Southeastern Soil & Environmental Associates, Inc.

December 2, 2003

Re: Septic system evaluation/recommendations, Woodshire Subdivision, Lot 13, Harnett County, North Carolina

PLOT PLAN

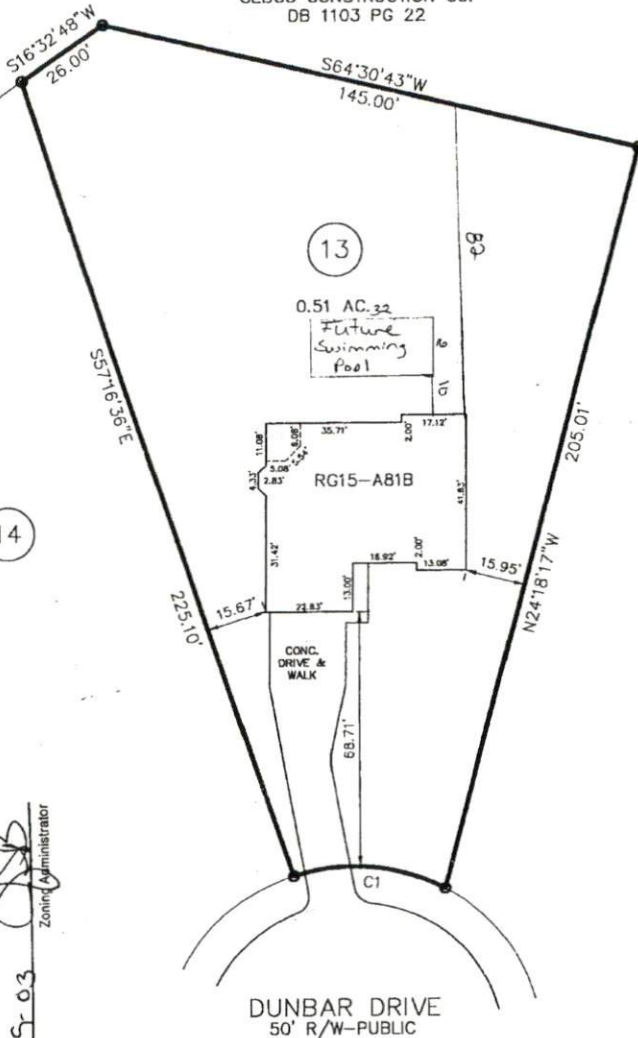
The proposed house could be located where proposed with a conventional septic system located behind the house. The only change required would be the driveway would need to be located along either lot line (typical of cul-de-sac lots).

It is my understanding, however, that the owner wishes to place a swimming pool behind the house. In order to accommodate the pool, the house would have to be shifted to the back of the lot and the system pumped to the front (in addition to moving the driveway) as proposed by the health department. The reason for this relocation is that there is a limited amount of usable soil for septic. Placing the pool behind the desired house location, would cover an amount of this limited soil thereby rendering the lot unsuitable as proposed.

The only solution would be to relocate the house to the back where the pool could be installed in unsuitable soil areas.
